Response to TfL comments dated 21st of October 2025 to Planning Application Reference 79625/APP/2025/2128

The proposals seek Outline Planning for the redevelopment of the Site which includes Buildings HPH2 and HPH5 along with the Multi-Storey Car Park and the surface car park to the north of HPH2 to provide up to 652 apartments along with associated parking and landscaping. This note provides a response to the TfL comments with a copy of the full consultation response provided at **ANNEX A**.

A map showing a red line running diagonally across a green area, labeled "LINGTON ROAD".

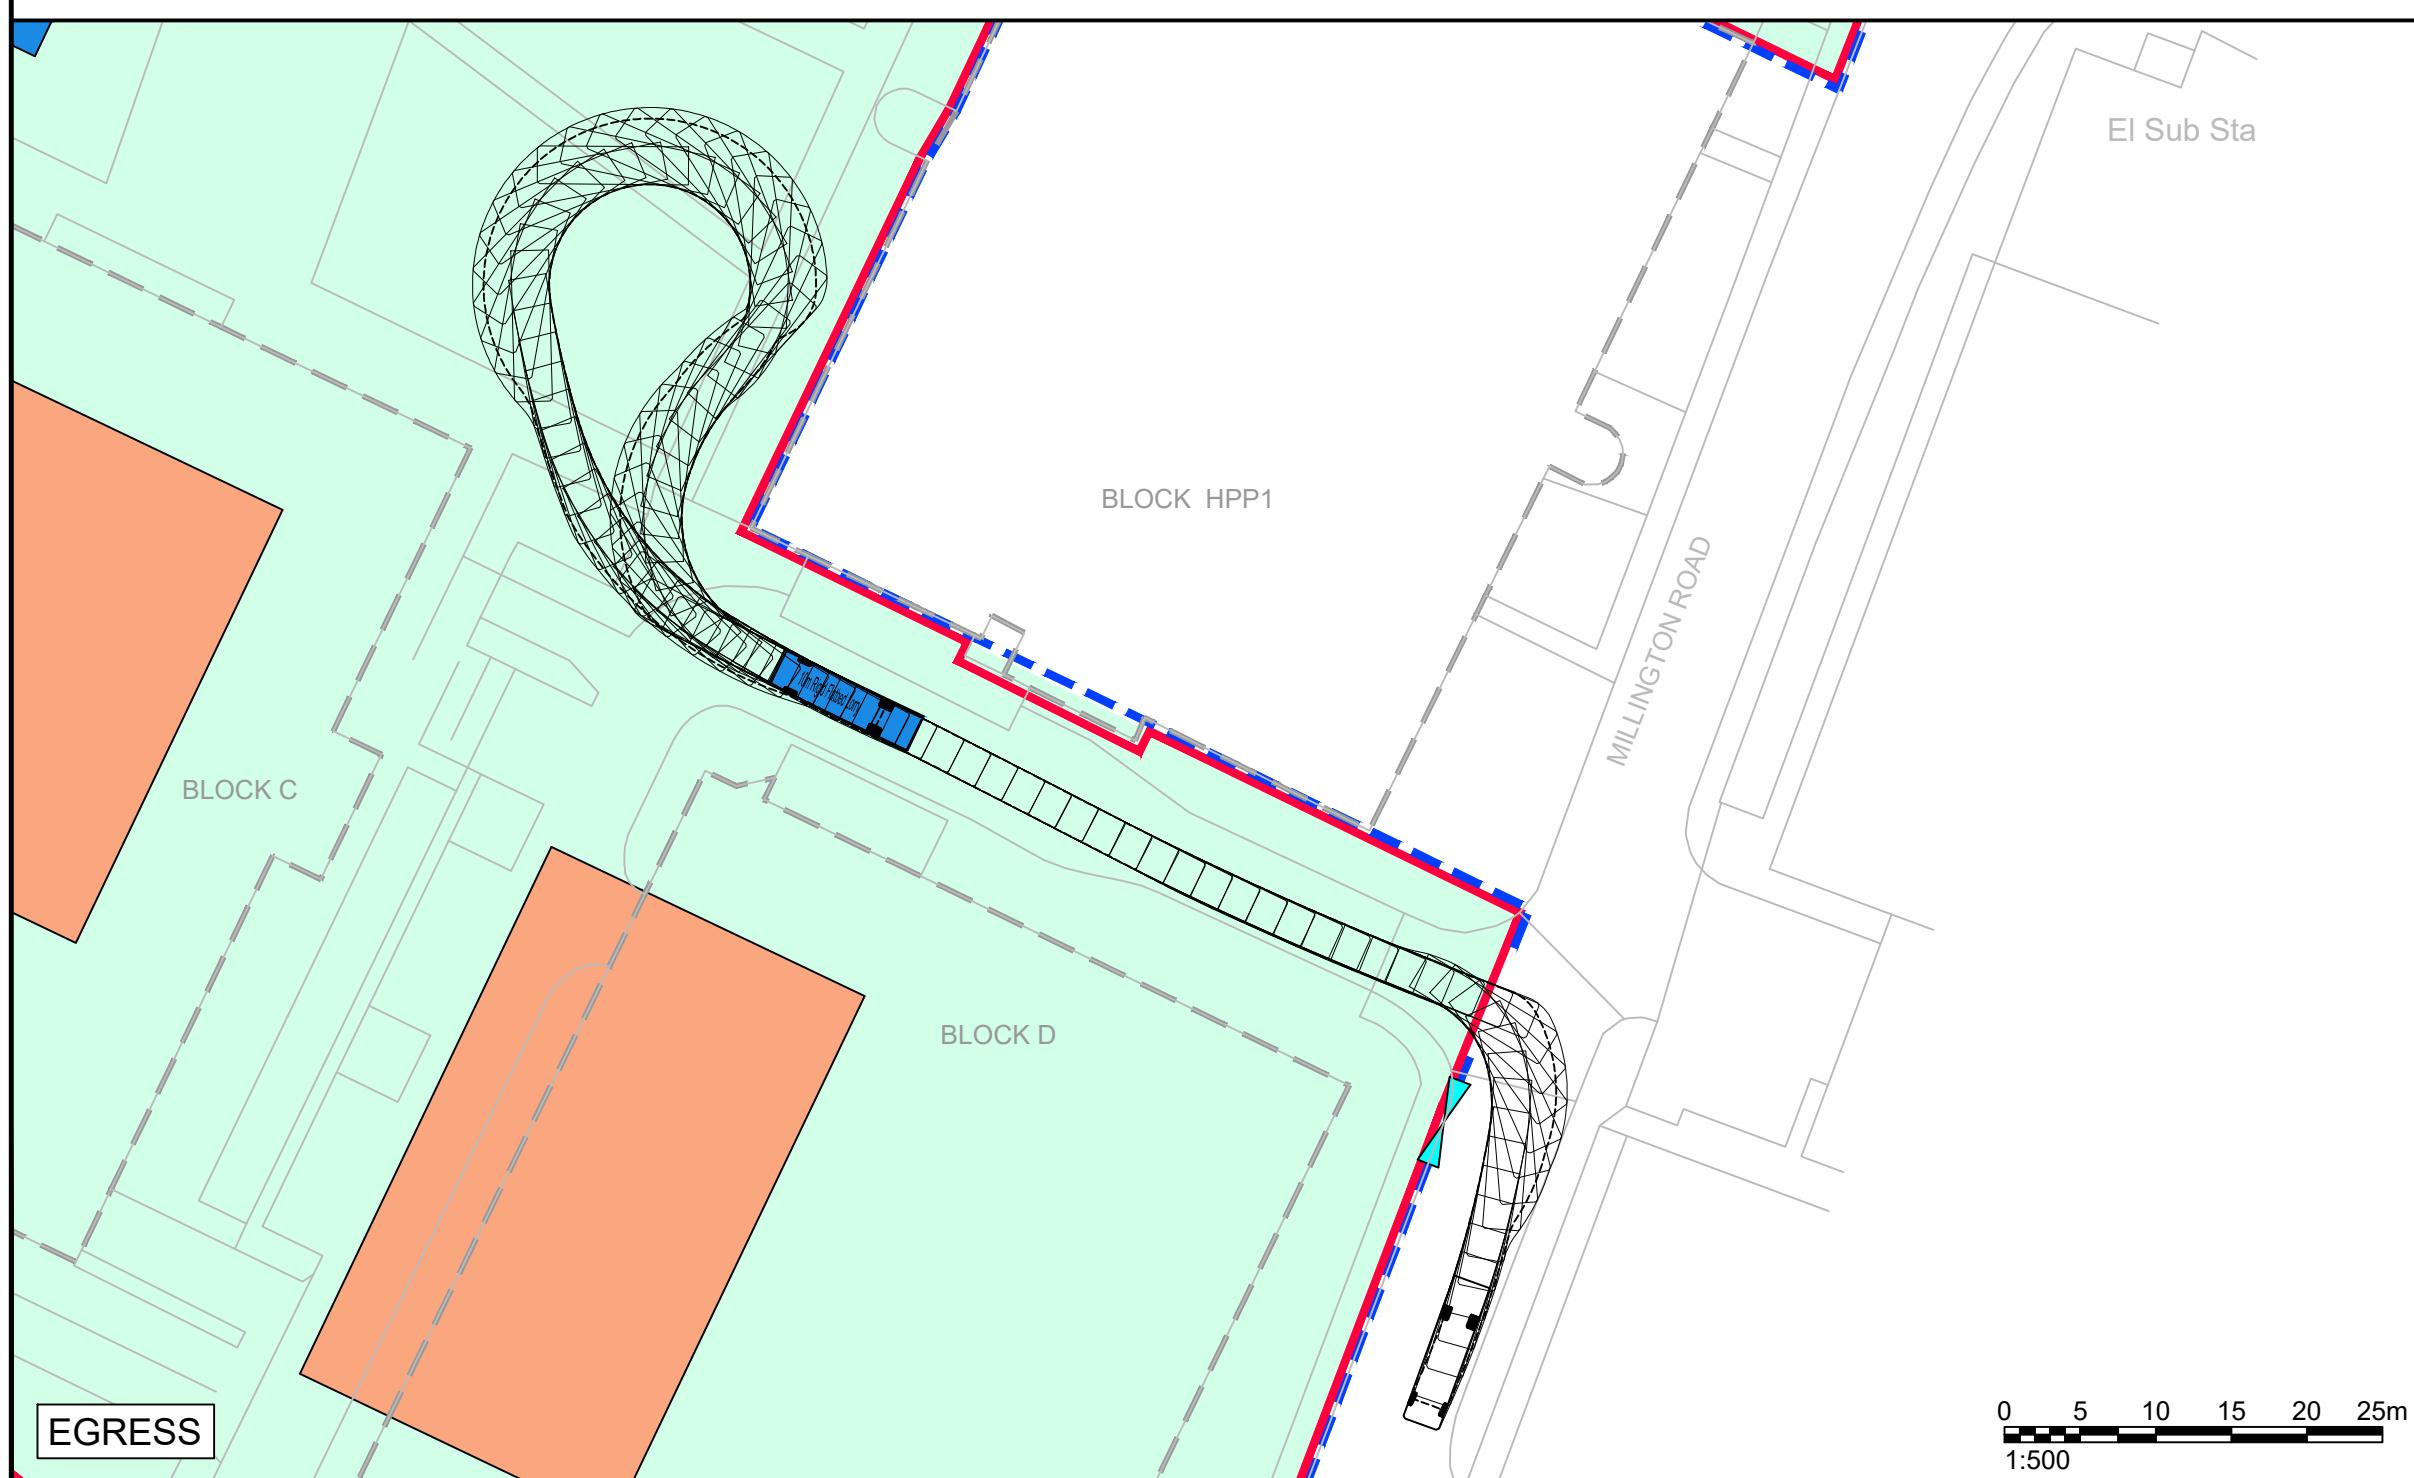
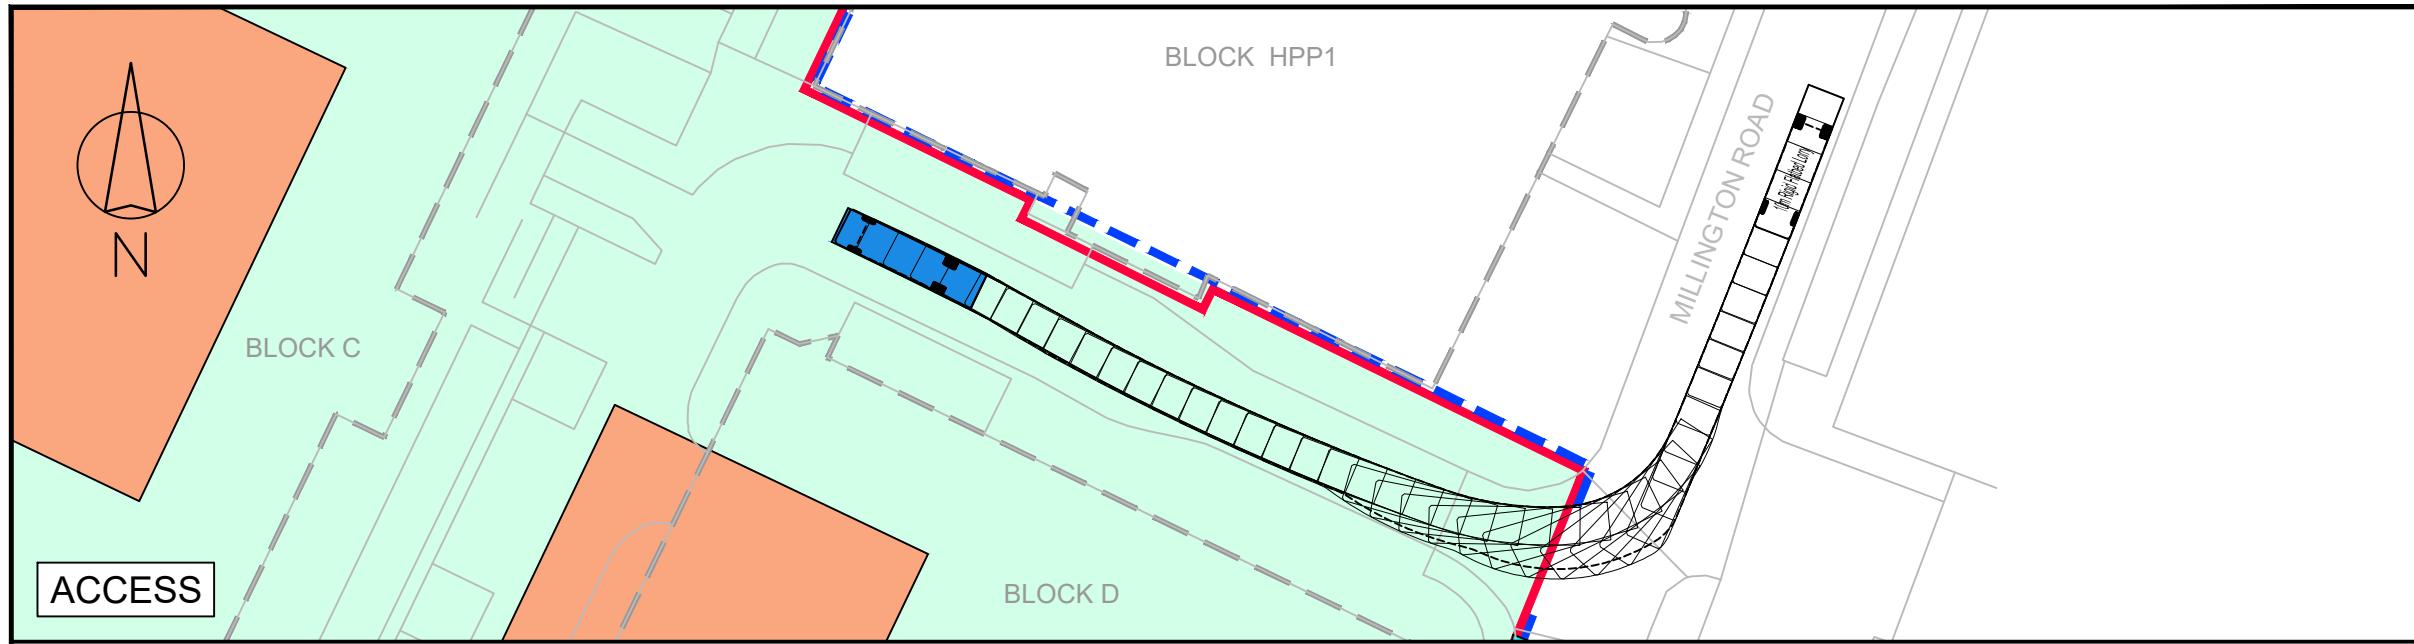
Movement in other directions is more compromised. There is likely to be demand to use Millington Road (South), for access to Station Road, with its bus services and local facilities, and Asda. But, as is recognised in the ATZ, this offers a relatively poor pedestrian environment, where vehicular accesses take pedestrians away from their desire lines. The ATZ makes no commitment to supporting any of the interventions highlighted, but there is a strong case for implementing improvements to Millington Road (South), given its key role in supporting sustainable travel to and from the site. A contribution towards improving routes to key trip attractors would be appropriate.

At some thresholds to the site, however, the character of streets and public spaces does not lend itself well to a residential environment, which may have an adverse impact on use of active travel modes as well as quality of life for residents. The threshold to the south (interface between Millington Road and the Geiger-UK building) is challenging and it is noted that there are no building entrances on this side of the development, and pedestrian flows are likely to be very light. To support personal safety in a quiet and potentially isolated area, planting between footways and carriageways should be kept low so as maintain a strong visual relationship between the two.

Whereas it is acknowledged that there would be pedestrian demand to / from the south via Millington Road (South), the majority of pedestrian demand is anticipated to be to / from the north with the primary pedestrian access to the ASDA being on the north-eastern corner of the store along with the presence of the railway station and numerous bus stops. Notwithstanding this, the Applicant is willing to look to implement appropriate measures along Millington Road (South) to enhance pedestrian and cycle facilities along the corridor.

The final landscaping scheme which is likely to be subject to condition discharge will take into account a number of factors including permeability along with safety and access along with maintenance requirements.

Figure 3.1: Ground Floor Parking Locations (as shown on Illustrative Masterplan)

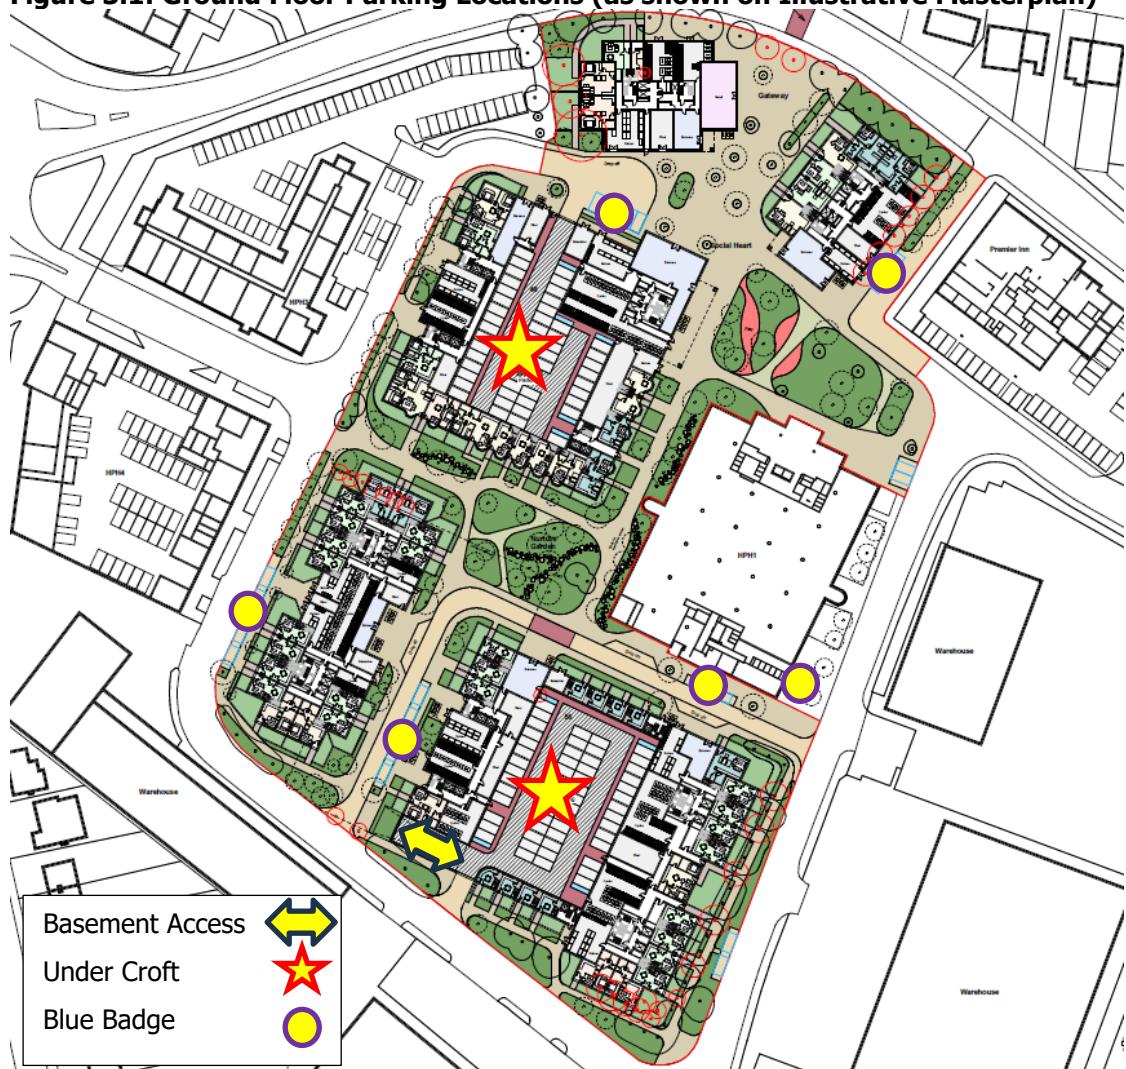
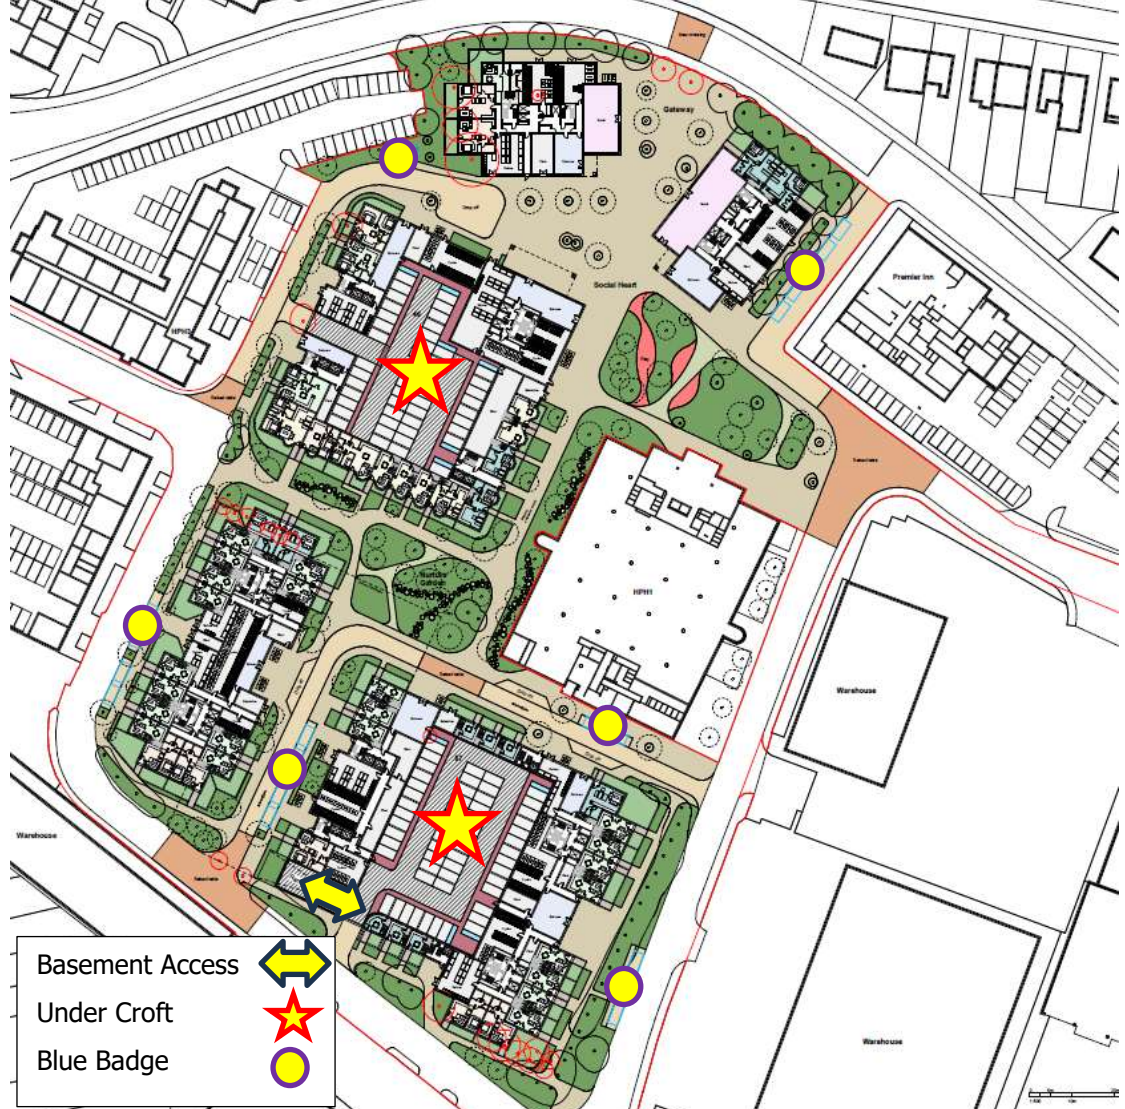
The reduction in the quantum of car parking spaces at this site is welcomed. A parking ratio of 0.2 spaces is proposed. Noting the sites accessibility, a car-free scheme at this site is strongly encouraged. 112 spaces are to be retained at this site, provided for existing commercial elements. The Parking Design and Management Plan should detail how these spaces will be removed as and when they are no longer required and/or commercial lease agreements expire.

The Applicant is willing to accept a condition to implement a Parking Management Plan.
